Householder Proforma

Application Ref: 2021/0942
Address: 32 School Street, Darfield, Barnsley, S73 9ET
Neighbour Representations: No
Consultations: Highways – no comments received
Property Description: the link detached property is located in a predominantly residential area, within a row of similar dwellings of varying styles. The dwelling benefits from a parking area to the front of the property and occupies a modest plot with open green space beyond the rear boundary.

Proposed Extension: Erection of a first floor side extension, and two storey and single storey rear extensions.
UDP Designation: Housing Policy Area
Local Plan Designation: Urban Fabric
Conservation Area: No
Relevant History: N/A
Acceptable in Principle: Yes

Drawing Title
PROPOSED ELEVATIONS

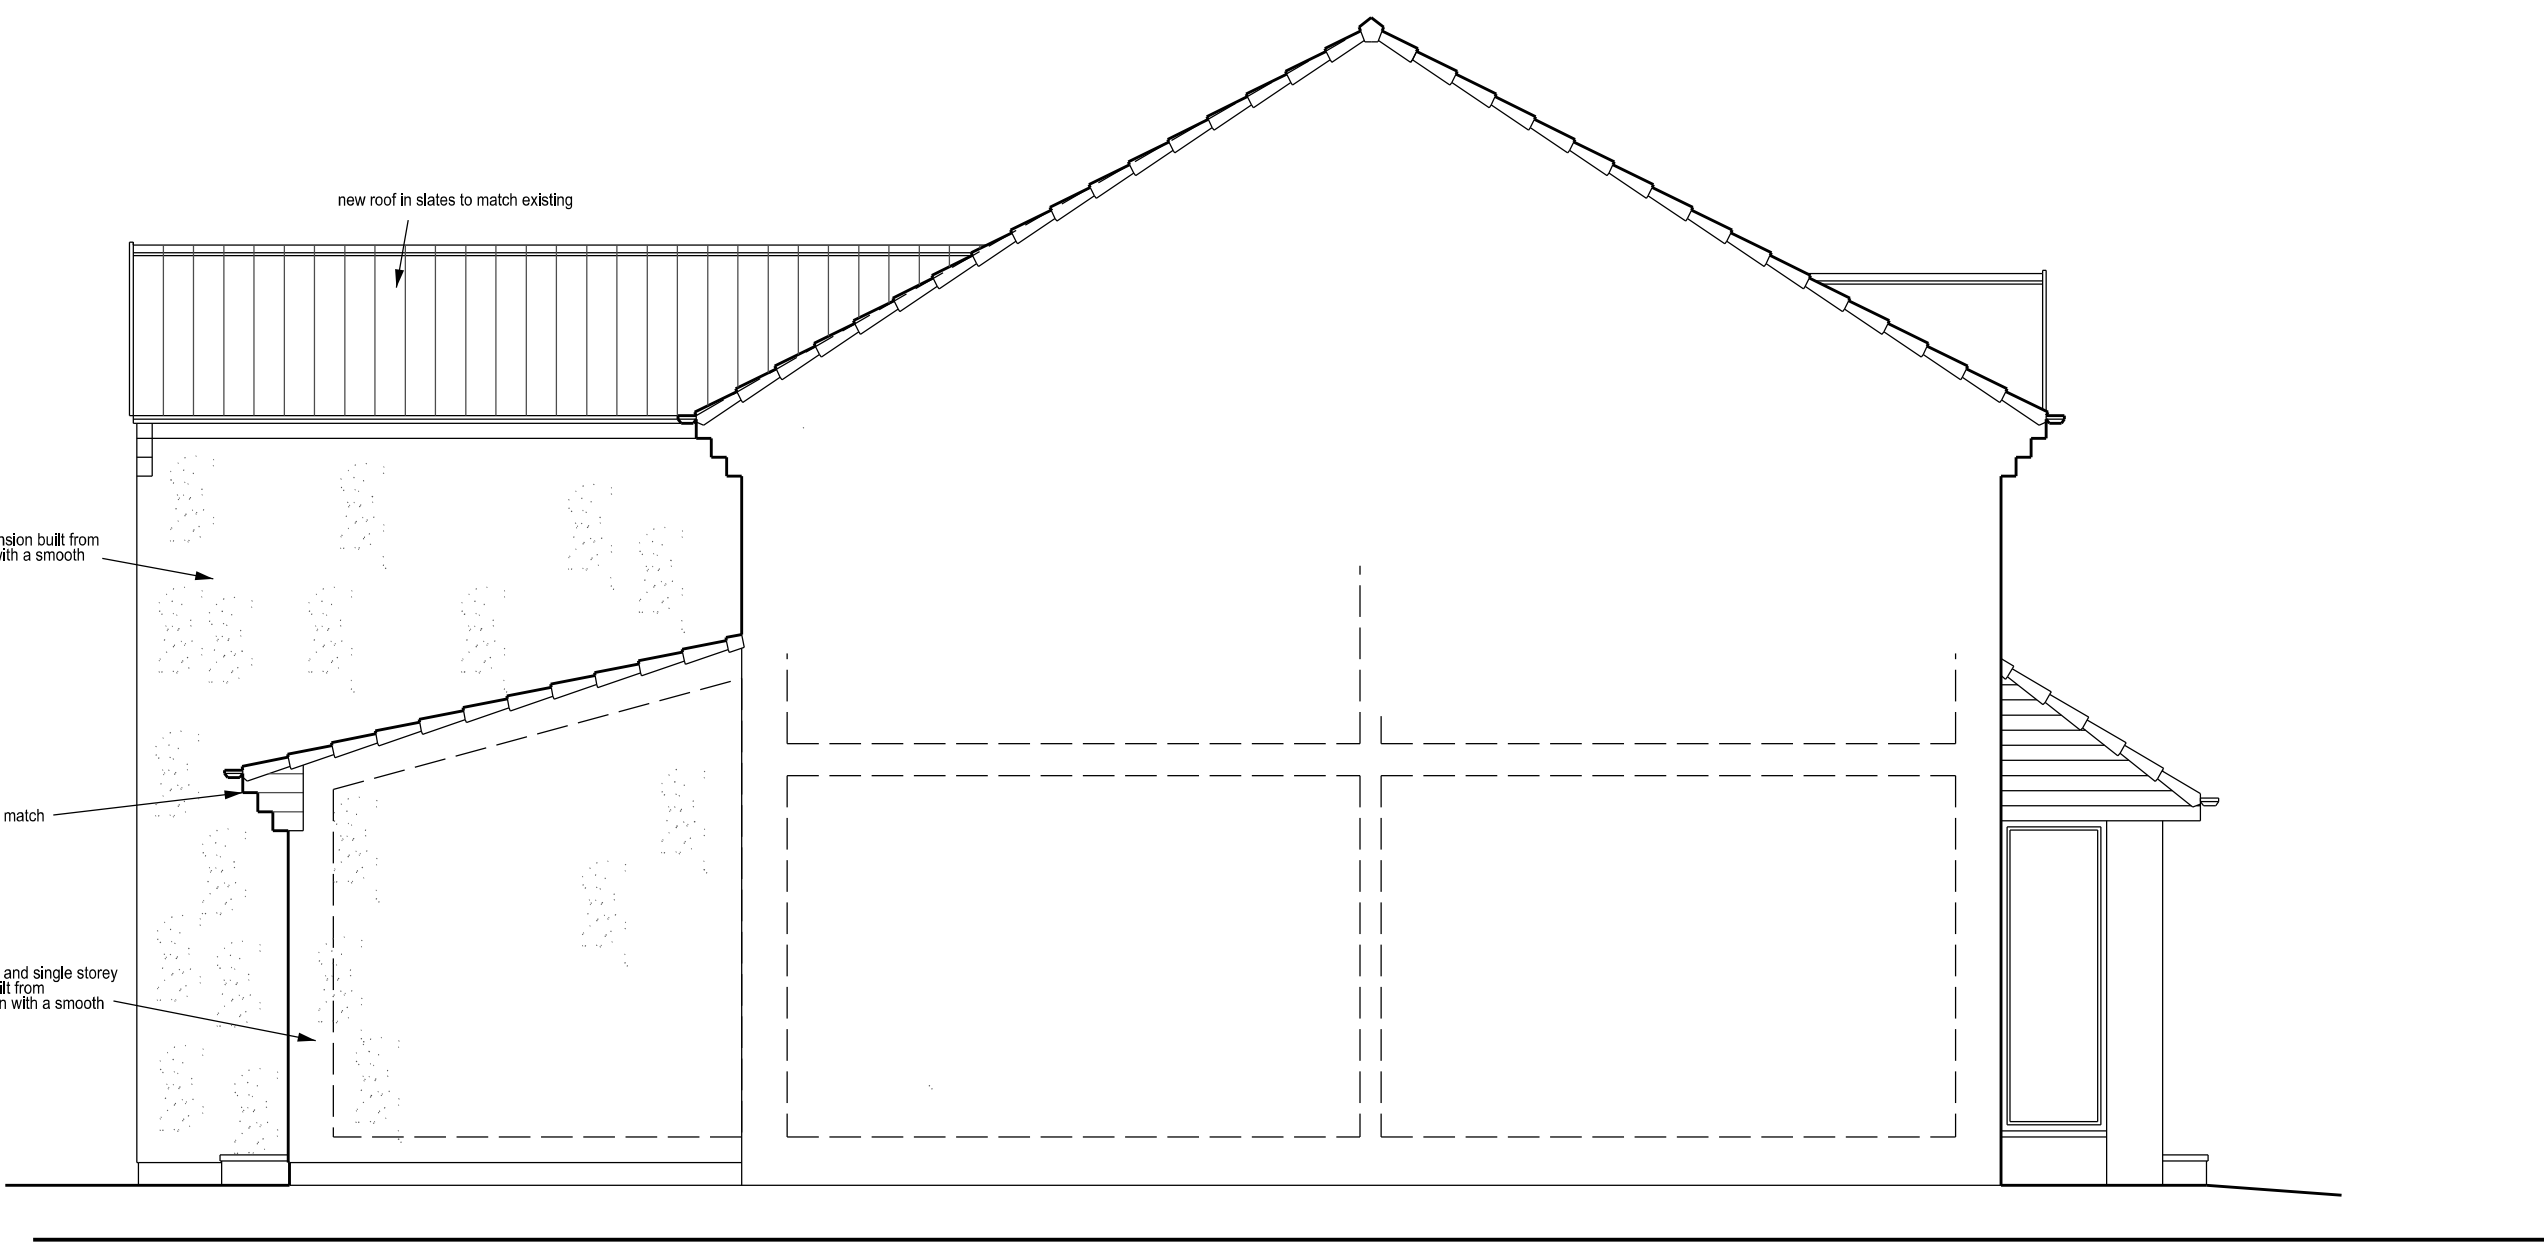
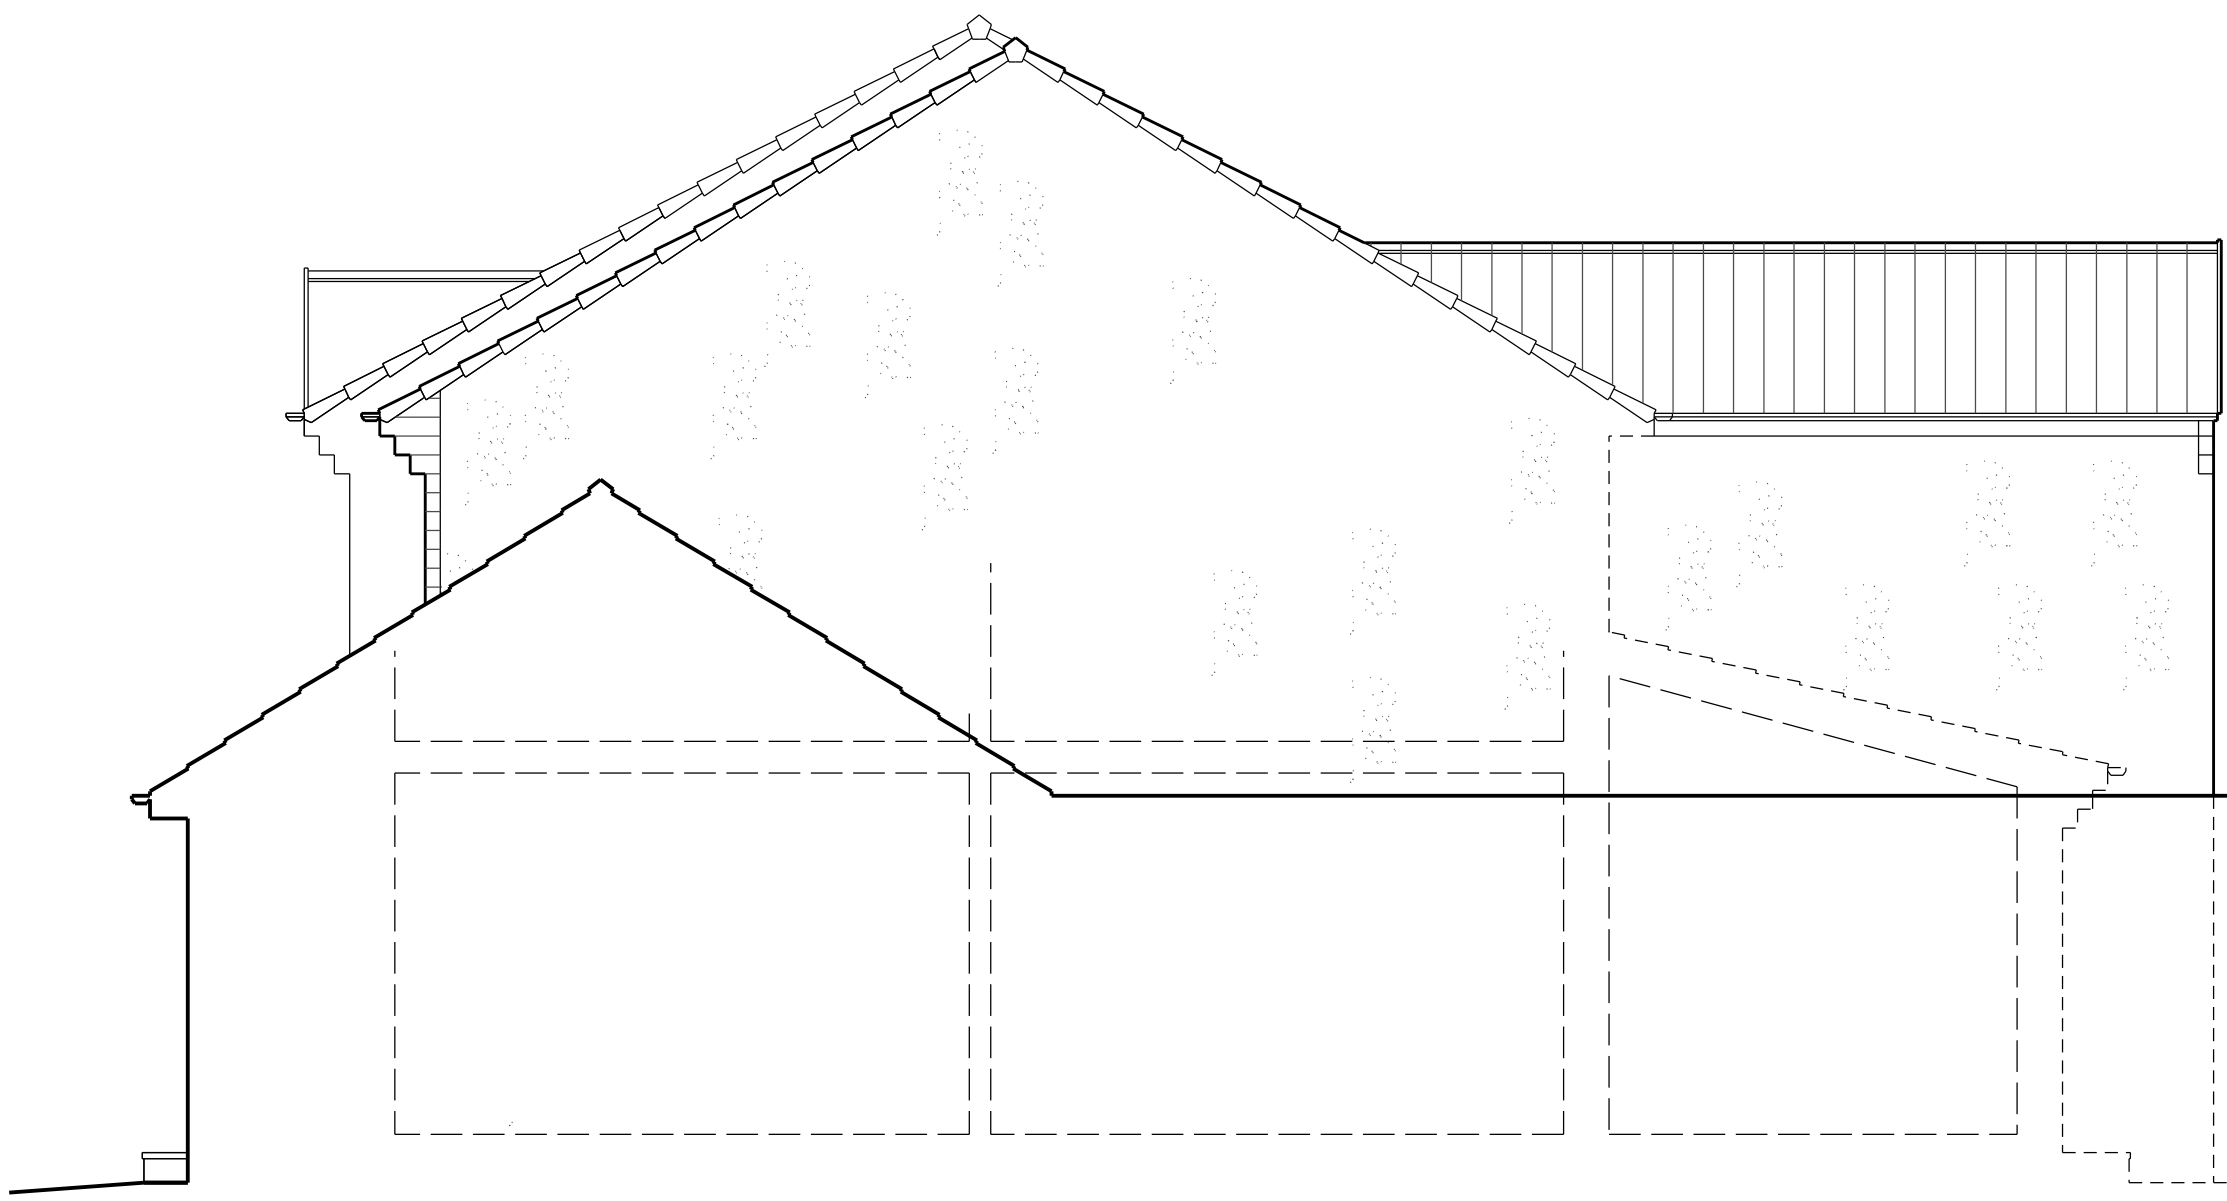
A set back of 500mm at first floor level has been incorporated allowing for a corresponding lowering of the ridge line and the extension doesn't have a width greater than 2/3 width of the property ensuring the original dwelling remains the dominant feature.

The side extension is to project 4m beyond the rear elevation at two storey level, the extension is situated to the north of the neighbouring property and as such it is considered that the proposal wouldn't increase levels of overshadowing, in addition the neighbouring dwelling has outbuildings located along this boundary, therefore any overshadowing would be over these buildings rather than amenity space.

There are no windows proposed on the side elevation of the side and rear extension.

A Juliette balcony is to be located on the rear elevation of the two storey rear extension; a minimum of 10m is retained to the rear boundary, however there are no residential properties located beyond the rear boundary, which would not increase levels of overlooking.

The extensions have been designed to harmonise with the original dwelling in terms of roof design and the fenestration of windows and doors.

It is proposed to construct the side and rear elevations of the extensions in render with the front elevation being constructed from materials which match the original dwelling.
